**M54 to M6 Link Road**  
**TR010054**

**8.8 LA(B) Draft Statement of Common  
Ground with South Staffordshire  
Council**

**8.8 LA(B) Draft Statement of Common Ground with  
South Staffordshire Council**

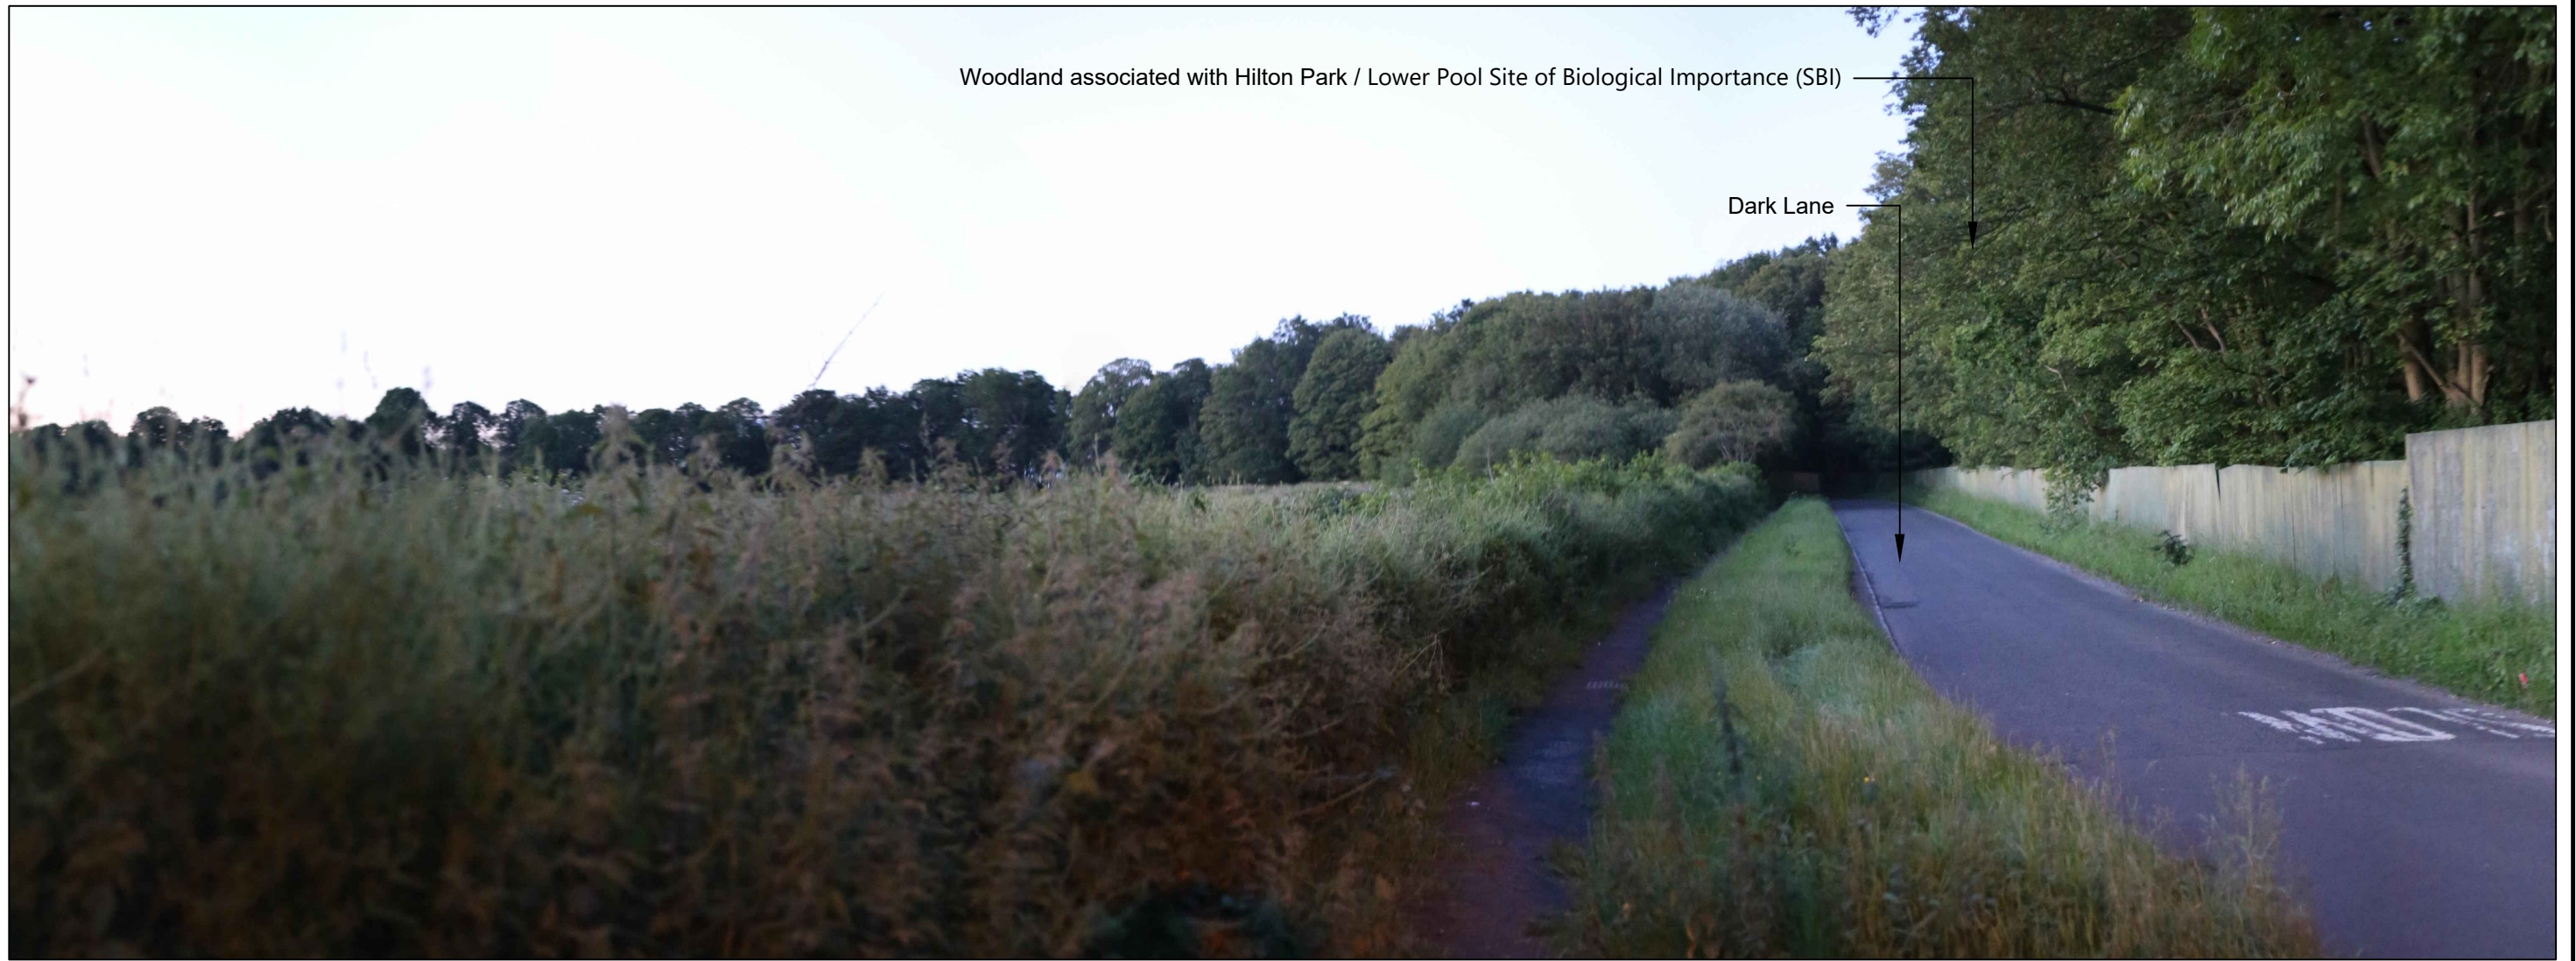
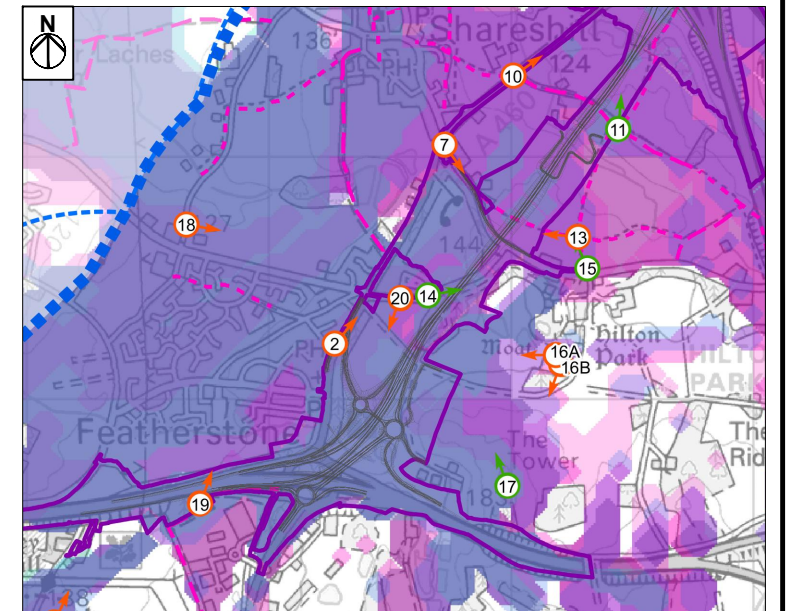
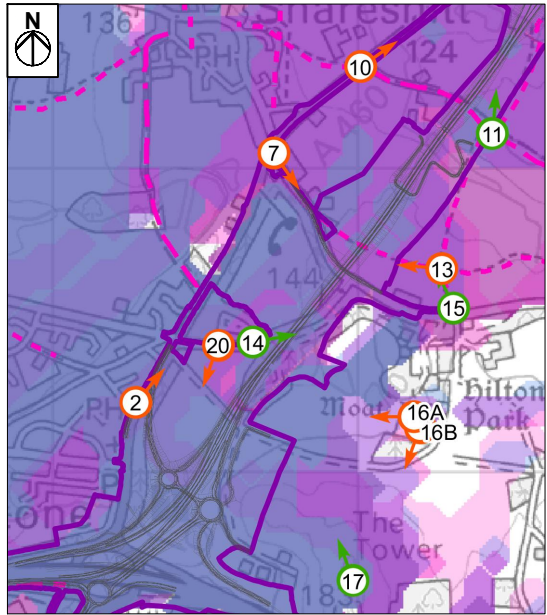
E.g. SSC's LIR page 17	Fence to the south of Dark Lane	SSC view the existing green fence to the south of Dark Lane as being	The fence is not within the highway boundary and is currently owned by the landowner of the adjacent land. The landowner would like the fence to remain	Under discussion	Medium

<p>unsightly and would welcome the replacement of this fence with a more visually pleasing boundary treatment (e.g. native species buffer planting) as part of the application.</p>	<p>and is concerned that the fence provides sufficient security for their remaining land. The desire for a secure boundary and SSC's desire for a visually pleasing boundary treatment are not necessarily complementary.</p> <p>Highways England is examining whether works to Dark Lane fence can be incorporated into the Scheme and will continue to work with SSC, the Parish Councils and the owner of the fence on this matter.</p>		
<b>5. Noise &amp; Vibration Effects</b>					
<p>Chapter 11: Noise and Vibration <b>[TR010054/APP/6.1]</b> and SSC's LIR p13-16</p>	<p>Noise and vibration</p>	<p>SSC is content that the ES appropriately assesses the effect of the Scheme on noise and vibration and that impacts would be managed through adherence to mitigation measures detailed in the OEMP. SSC agree that the mitigation measures proposed are appropriate (although please note line below on the height of noise barriers). SSC has no objection to the Scheme on noise grounds, having consulted SSC's Environmental Health officer.</p>		<p>Agreed</p>	<p>Agreed</p>

Plot Date: 25 March 2021 16:14:16
File Name: \\ukids2pfs04001\ukids2pfs04001\1\ENVIRONMENT\Practice Areas\GIS\Projects\M54.M6 Link\Workspace\Stage 4 Figures\landscape\HE514465-ACM-ELS-M54_SW_R_Z-DR-LS-003 to 007 - Figure 2.3 - 2.7 Env Masterplan P17.mxd

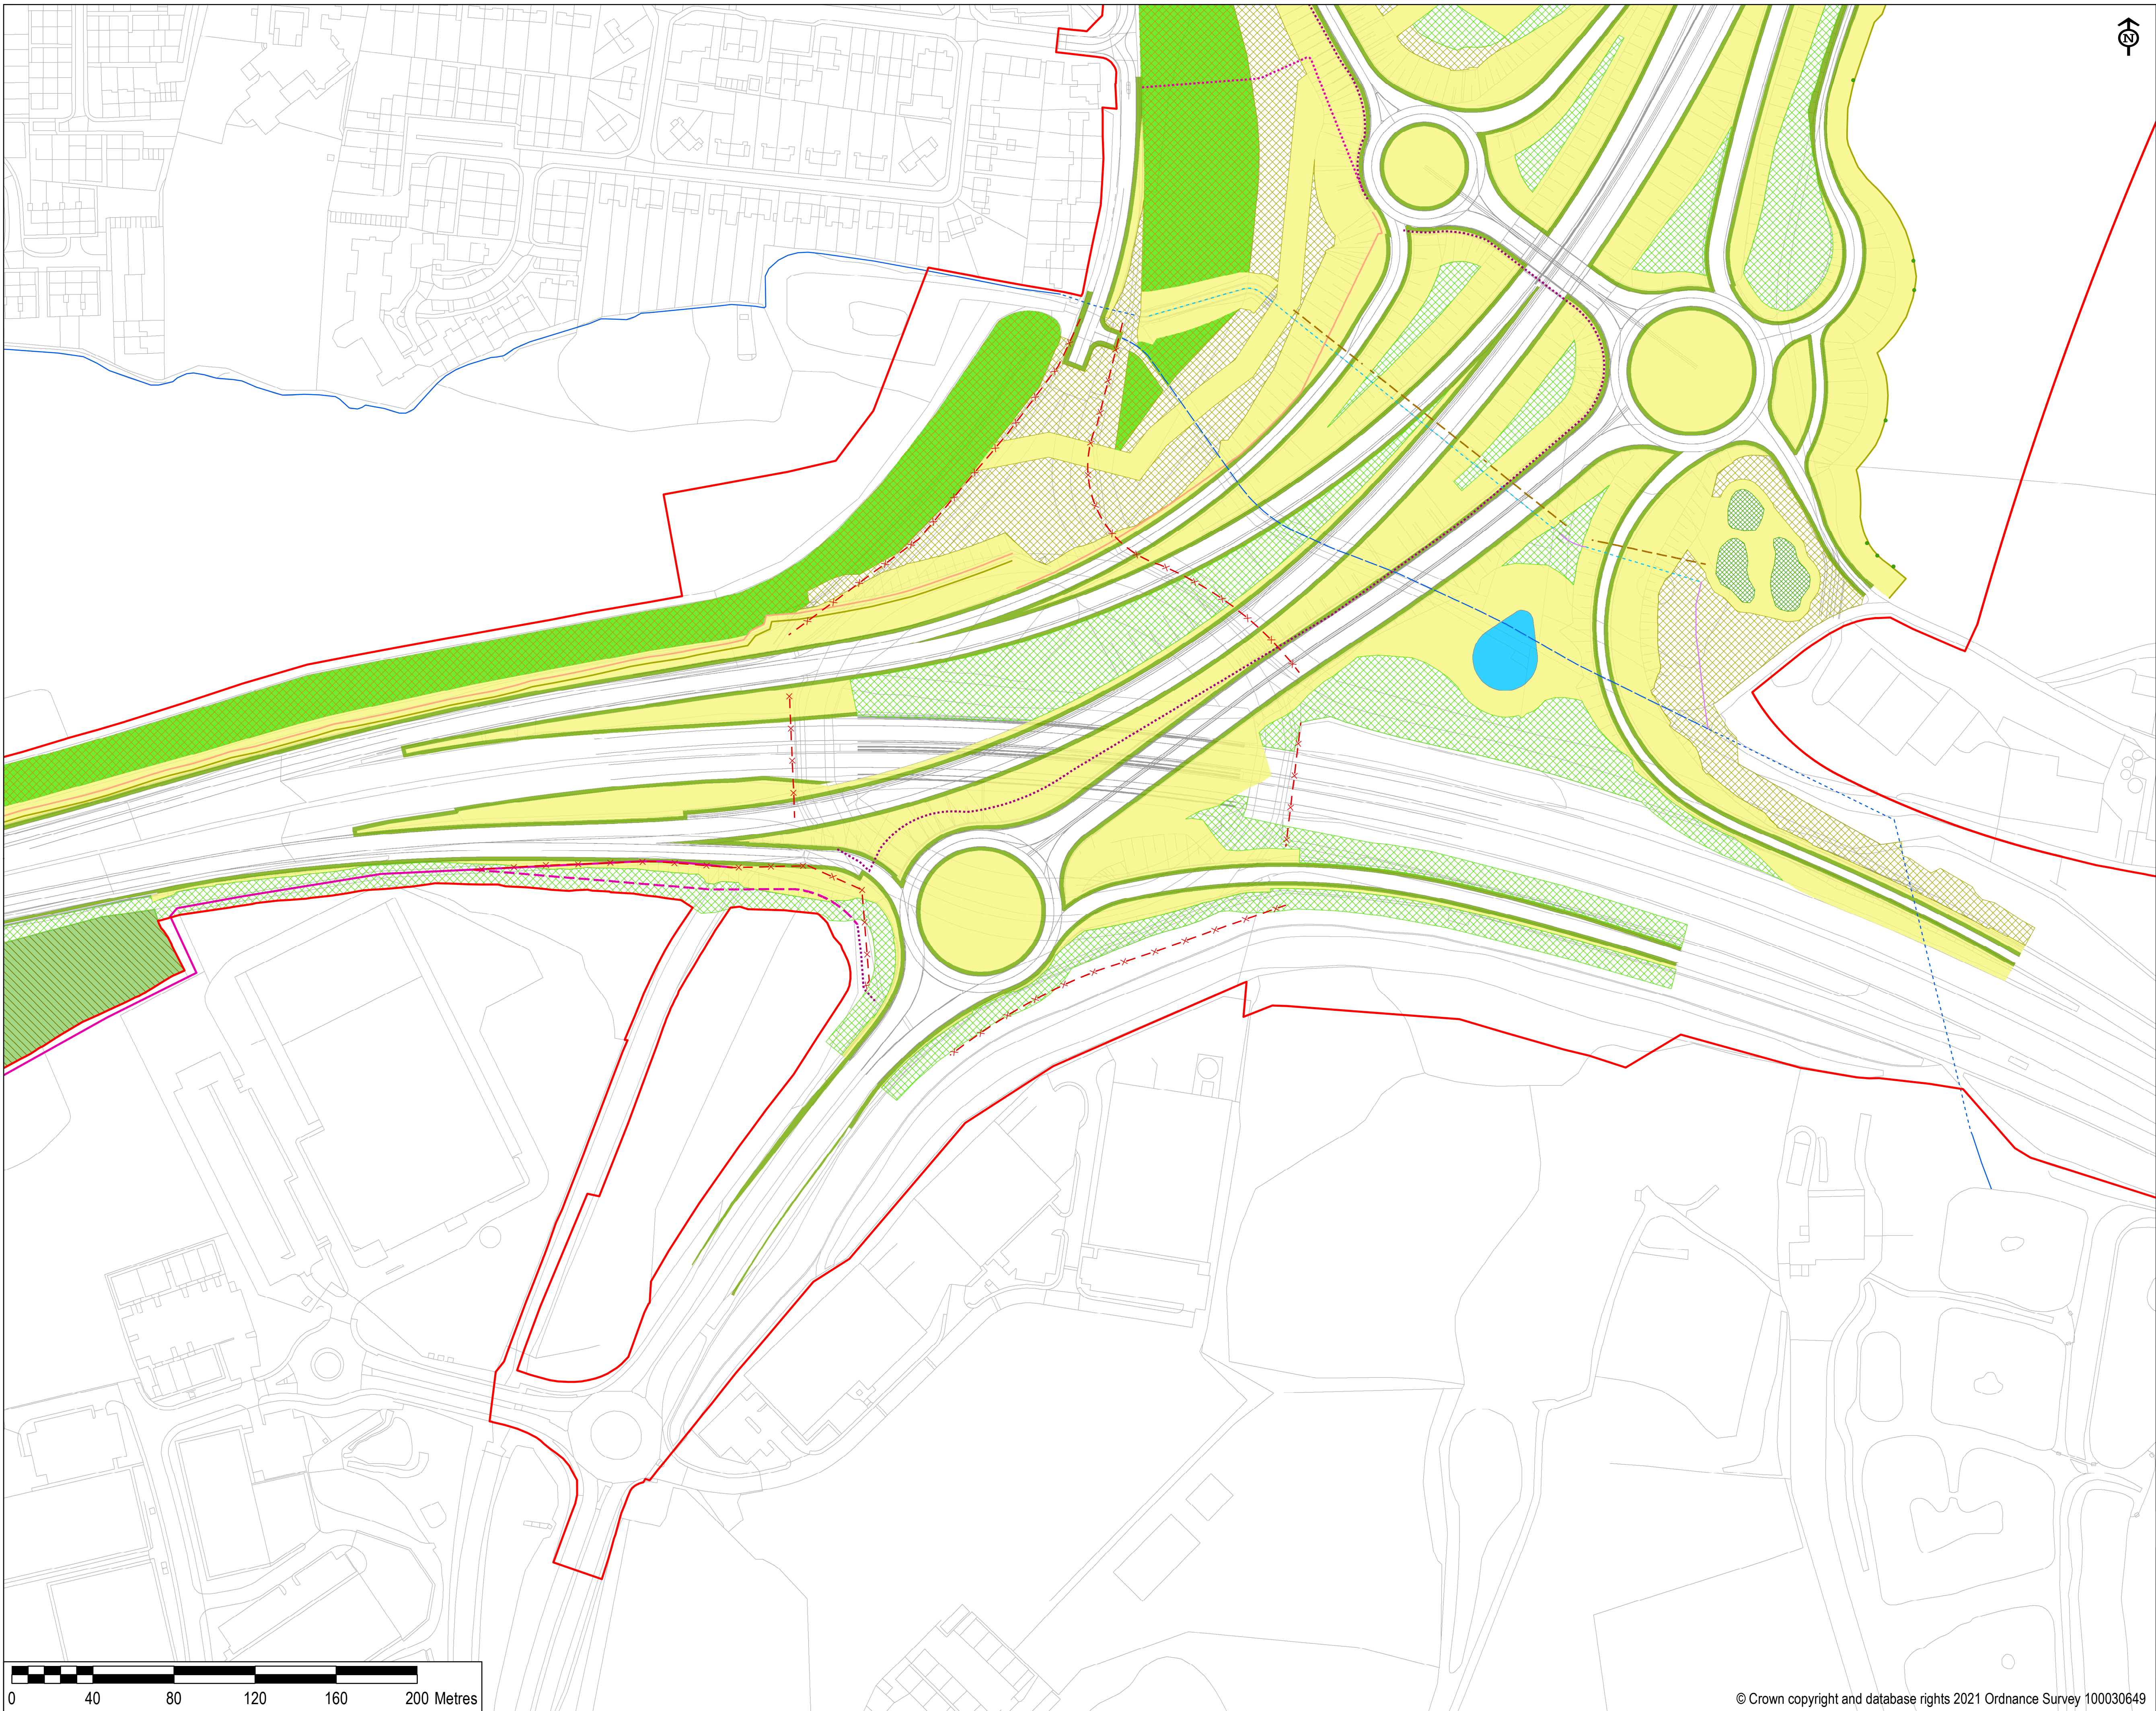
Other matters					
N/A	Mill Lane	SSC expressed concern that closing off Mill Lane where it meets the A460 will increase the likelihood of fly tipping and therefore request an appropriate gate be installed at any blocked roads with the appropriate authority.	HE listened to SSC's concerns on this issue. In addition to SSC's concerns, a number of local people voiced concerns that closure will require large articulated lorries to head north and pass through the village of Shareshill. There are tight bends, difficult junctions and pinch points along the alternative route that may cause difficulties for these vehicles and the local residents. For reasons raised by SSC and local people it is proposed that Mill Lane is kept open to traffic. This change was incorporated into the design prior to submission of the Application in January 2020.	Agreed	Agreed
N/A	Site Compounds	<p>SSC requests that the temporary site compound to the west of Junction 11 and Junction 1 is restored to its existing condition.</p> <p>SSC request that all planting proposals be conditioned.</p> <p>The two site compound areas would be permanently acquired by HE for environmental mitigation so would be restored in a way that would increase biodiversity and incorporate woodland screening (for the compound west of Junction 1). This means that the site compound areas would be restored, but not to exactly the existing condition.</p> <p>Requirement 4 on the draft DCO [TR010054/APP/3.1] ensures that no development will commence until a CEMP has been submitted and approved by the Secretary of State (following consultation with SSC and SCC). The CEMP must reflect the mitigation measures set out in the Record of Environmental Actions and Commitments table (presented in chapter 3 of the Outline Environmental Management Plan [TR010054/APP/6.11]) which includes a wide range of environmental mitigation measures. Requirement 5 on the draft DCO similarly ensures that the developments is landscaped in accordance with a landscaping scheme, which should be based on the environmental masterplan</p>		Agreed	Agreed

(figures 2.1-2.7 in the ES [TR010054/APP/6.2]). These two requirements ensure all planting proposals are implemented. The parties agree that this is adequately secured in the draft DCO.			
E.g. SSC's LIR	Pedestrian Amenity	SSC would welcome HE exploring opportunities to improve local amenity for local people, eg. pedestrian safety close to areas of construction eg. a pedestrian crossing in Westcroft or improving footpath conditions and signage in Featherstone.	The proposals for improvements and diversions of Public Rights of Way are shown on the Streets, Rights of Way and Access plans [TR010054/APP/2.7] submitted with the application. No measures are proposed outside the Order limits as part of the DCO application. However, Highways England has accepted a 'Designated Funds' application for an initial feasibility study to identify opportunities to provide improved NMU routes along the existing A460. This will be developed in partnership with key stakeholders including SCC, separately to this DCO application. If the feasibility study concludes that local cycleway improvements would deliver tangible benefits for the local community, Highways England will undertake a prioritisation process to determine which schemes to apply Designated Funds to.	Under discussion	Medium
